REF. BR/160/11
CONTACT: MRS T CHAPMAN

SUBJECT: JULIETTE BALCONY NO 5 SEAFIELD TERRACE BOGNOR REGIS

Planning Application BR/160/11 - 5 Seafield Terrace
Mrs H Thomas/Case Officer Mrs J Chapman

PROPOSED PLANS,  
SECTION & ELEVATION

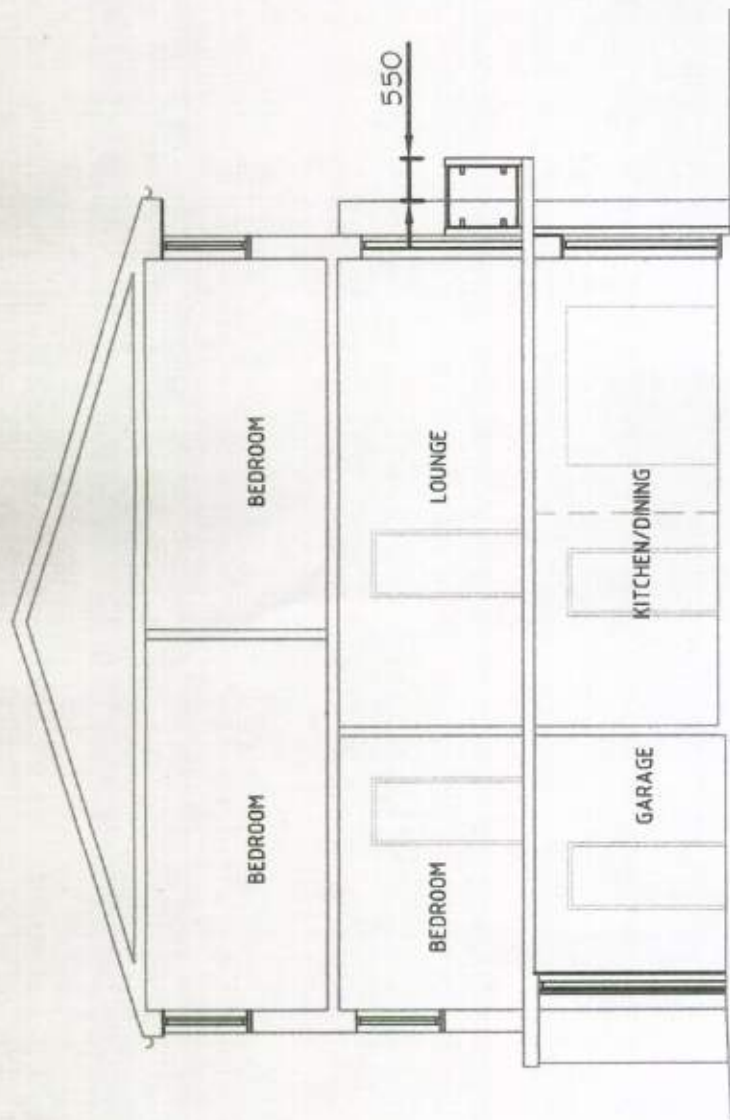
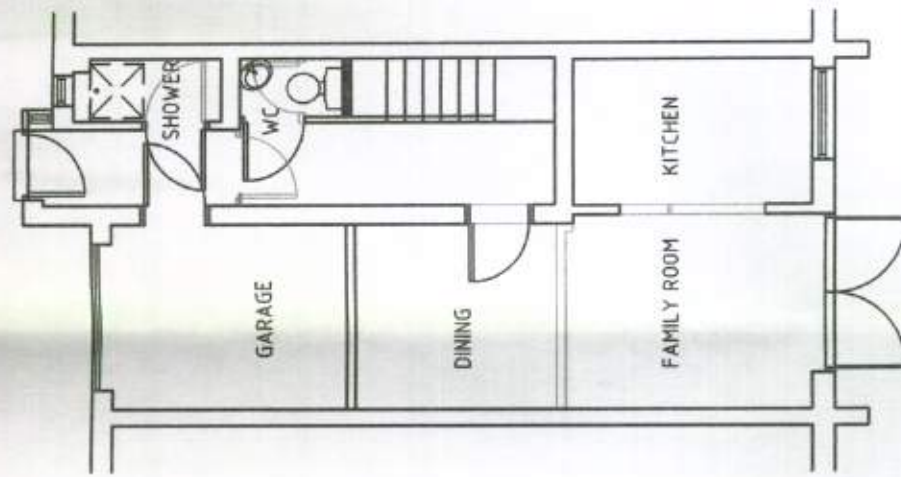
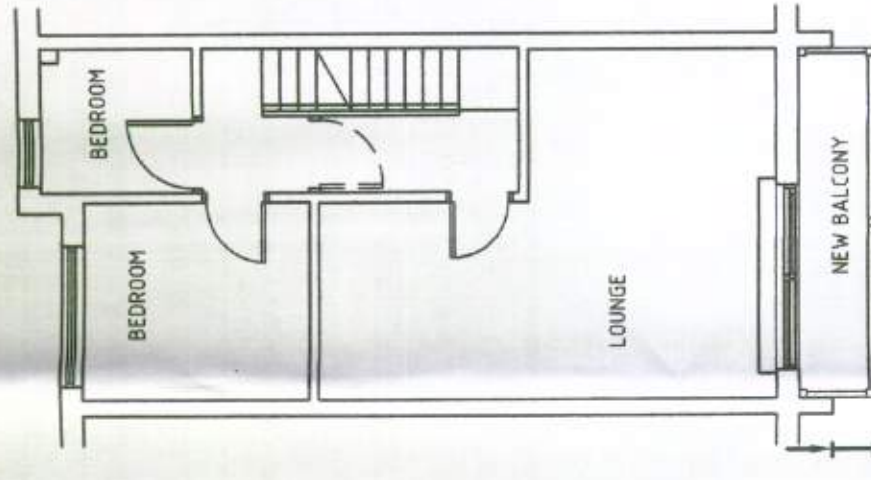
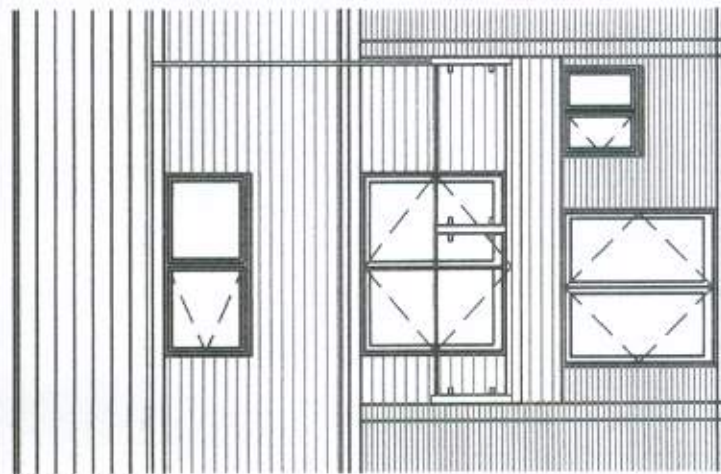
This plan is ~~reminiscent~~ the same as the one ~~refused~~ by the council in May 2010, with the addition of the word Juliet, and its width and depth similarly too big.

The balanced flue under the proposed balcony has appeared in recent years and the prevailing west wind blows fumes into our windows and could be a hazard to use of the new balcony and the balcony floor might direct more fumes towards in No 4.

The proposed balcony is to be constructed of galvanized steel frame, aluminium sections and toughened glass, which is out of character with the adjoining properties. The balconies at numbers 2, 3, 4 and 6 Seafield have railings and although they are not identical they are of a similar style.

The proposed balcony is deeper than those at the adjoining properties, which are less intrusive and I am concerned that it will have a detrimental affect on the privacy of the neighbours, in particular the occupants of No 6.
